8th February 2013

Application for Planning Permission for Works or Extension to a Dwelling

Development Demolition of existing extension and outbuildings and new single storey extensions.

Location Well Gardens Norton Lane Aldingbourne

EXISTING ELEVATIONS

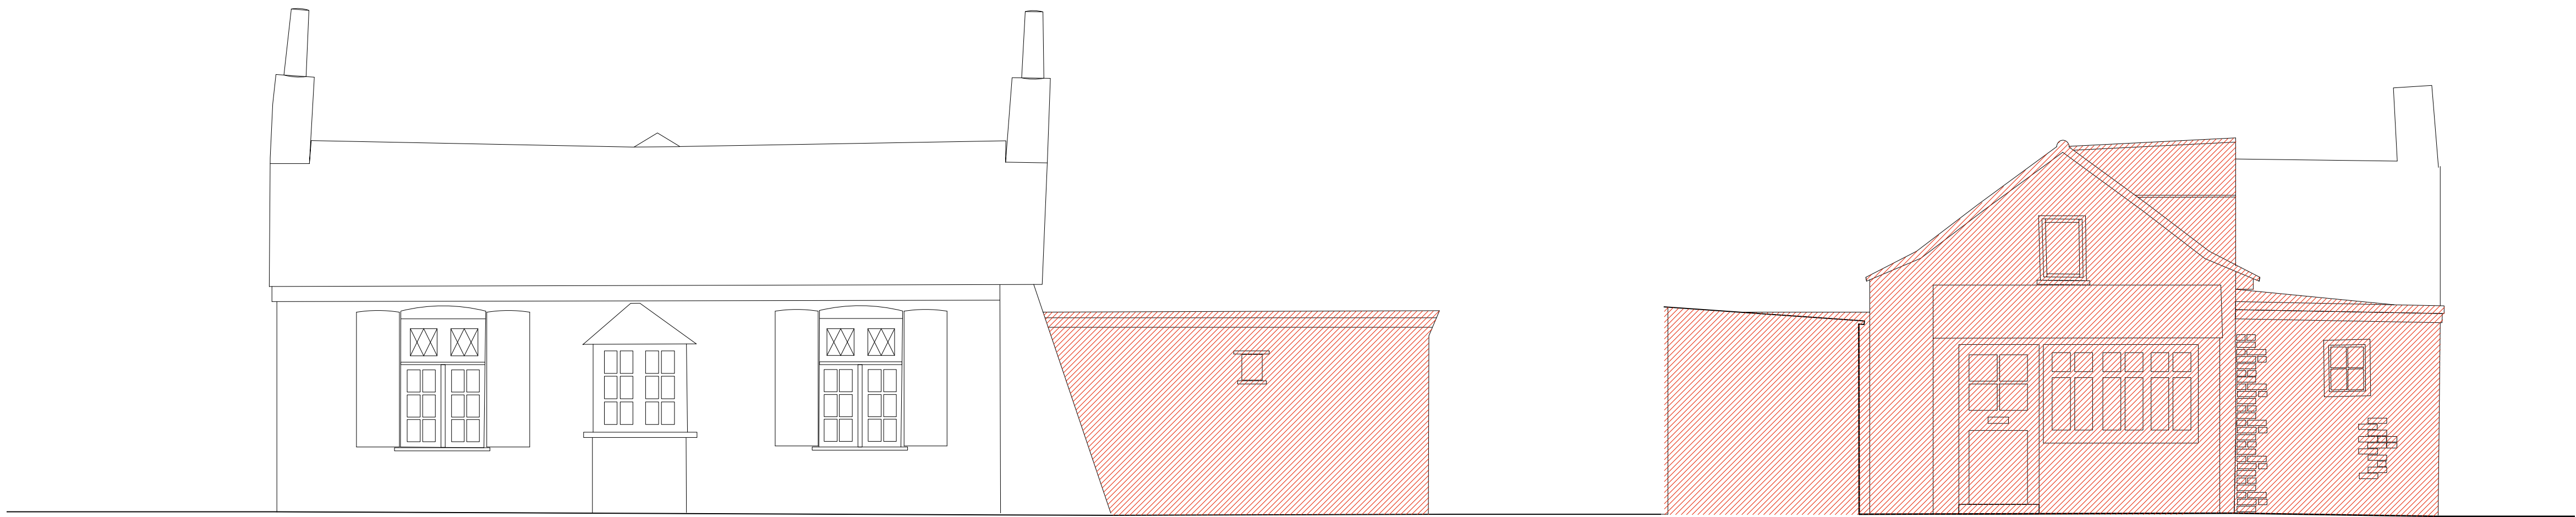
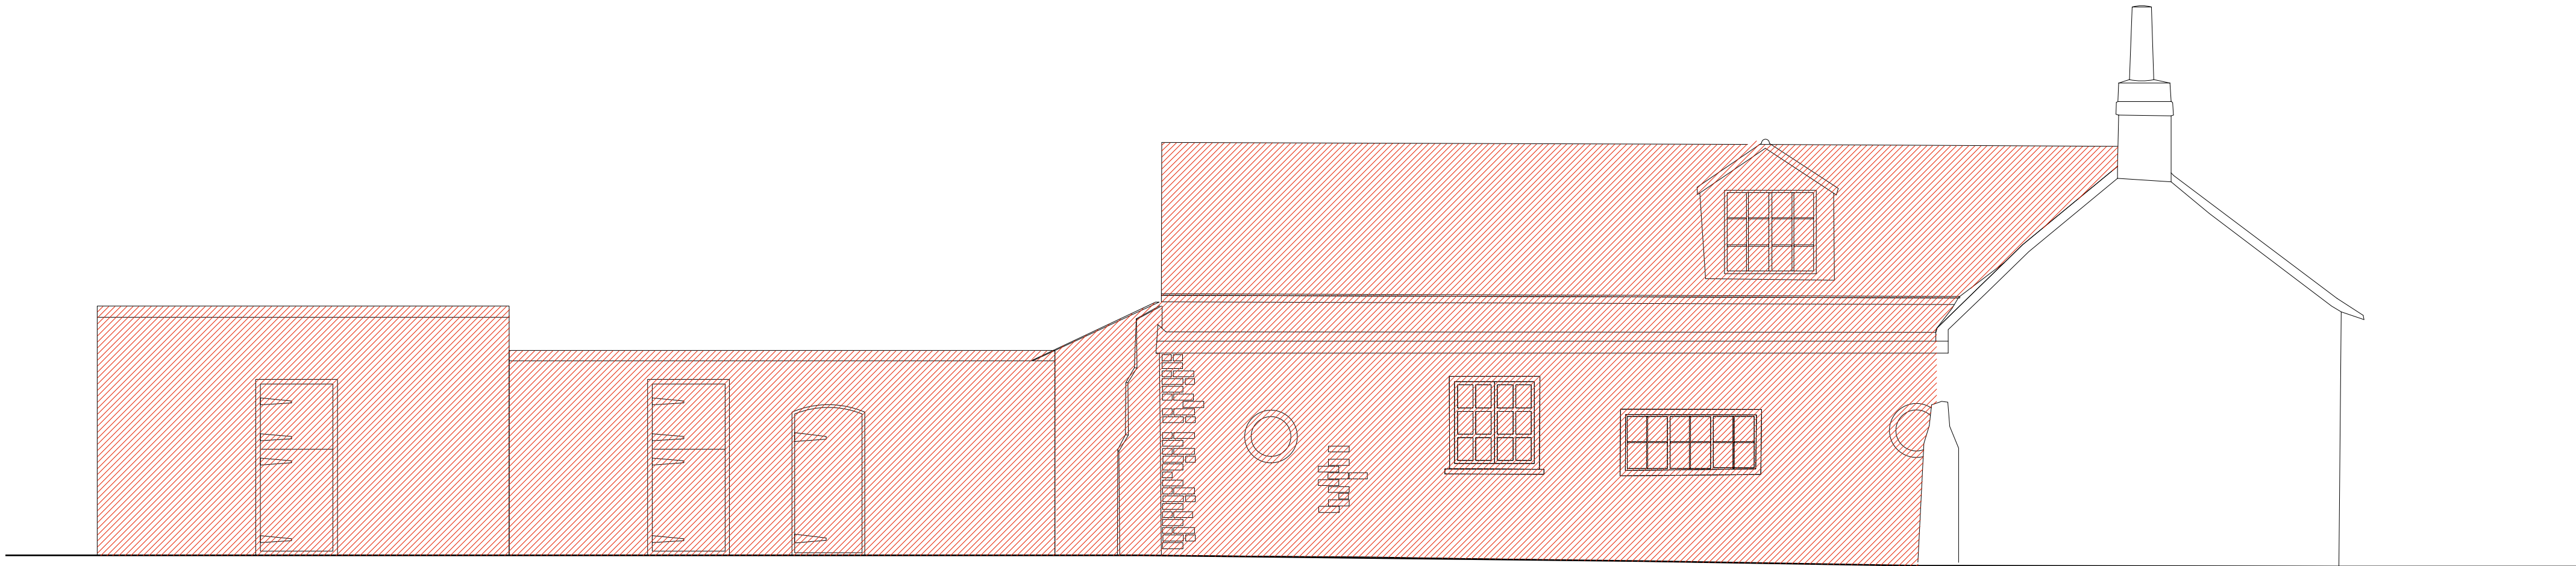
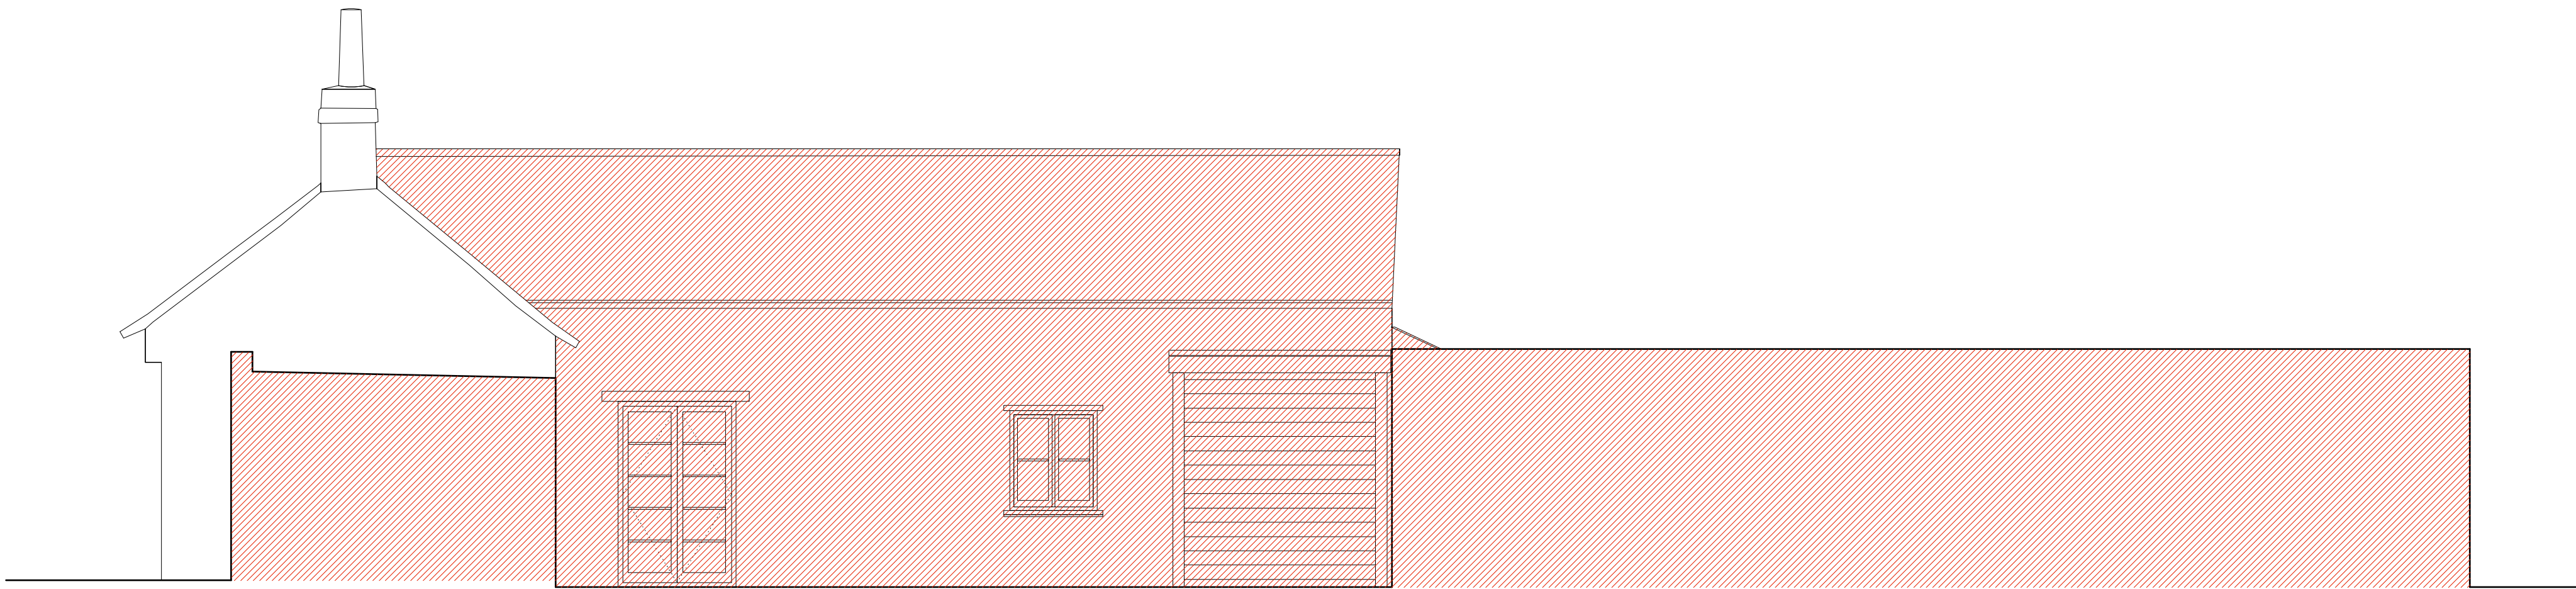
Please provide both existing and proposed elevations for the other 'side' elevation.

Please label Plan PO4A as 'Existing Elevations'.

The existing rear elevation at first floor level does not accord with the existing first floor plan. Please amend accordingly.

The existing rear elevation at ground floor level does not accord with the existing rear floor plan at ground floor level. Please amend accordingly.

The existing side elevation at ground floor level does not accord with the existing side ground floor plan. Please amend accordingly.

EXISTING SECTIONS AND ELEVATIONS

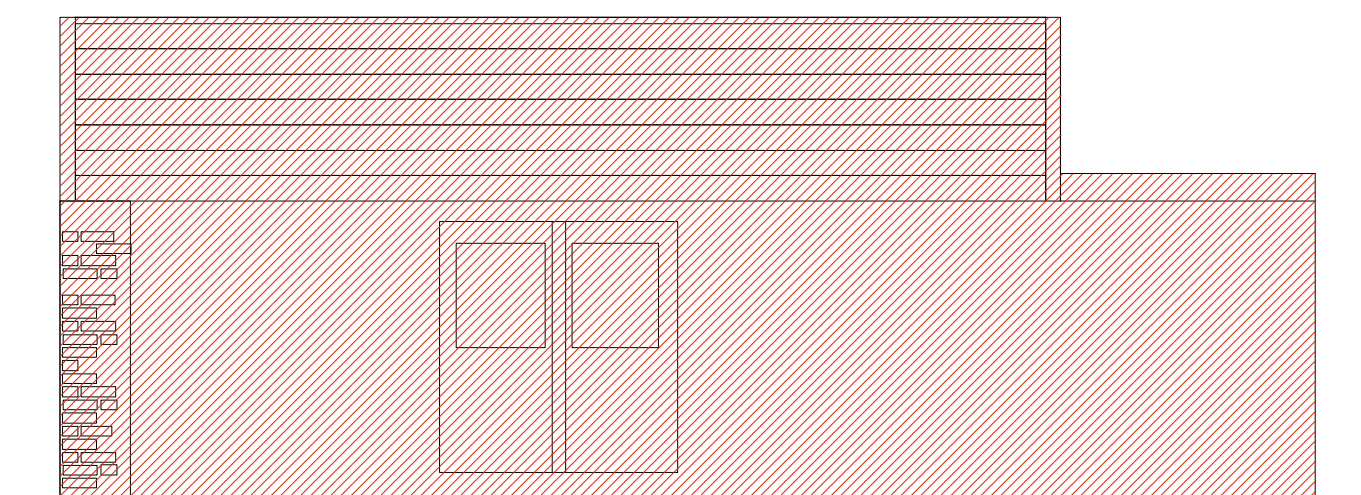
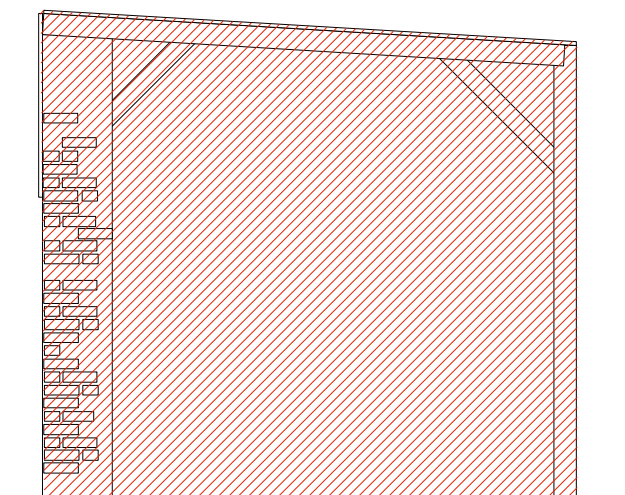
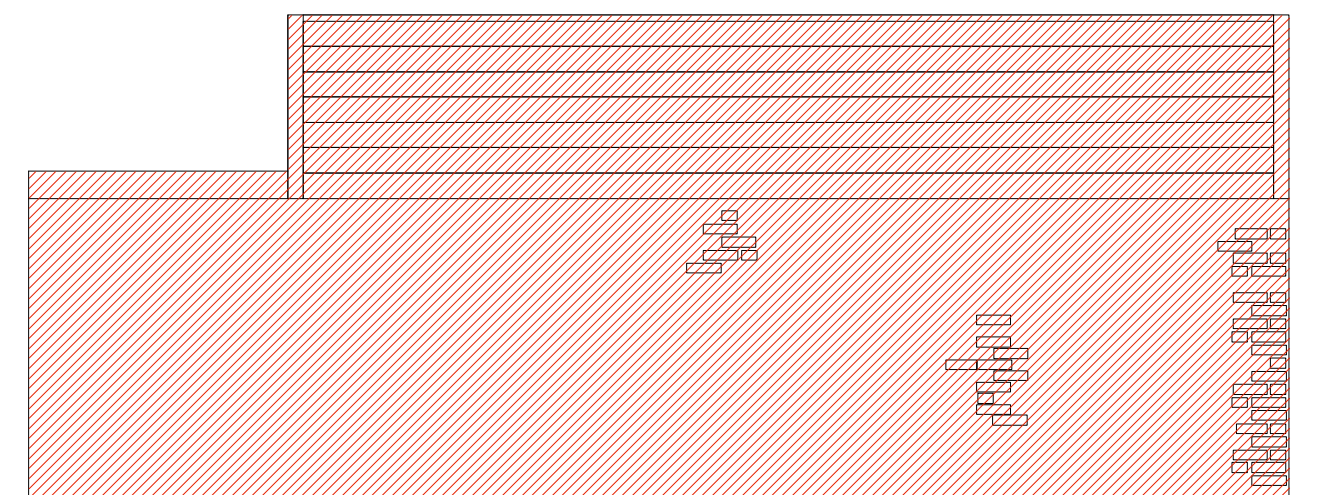
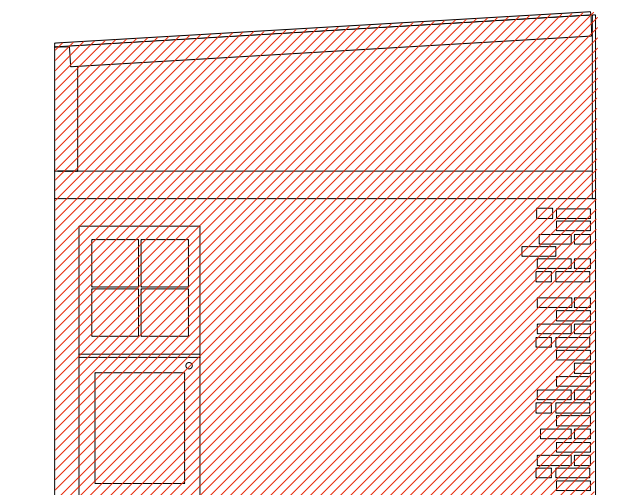
Please provide existing and proposed elevations for the outbuilding.
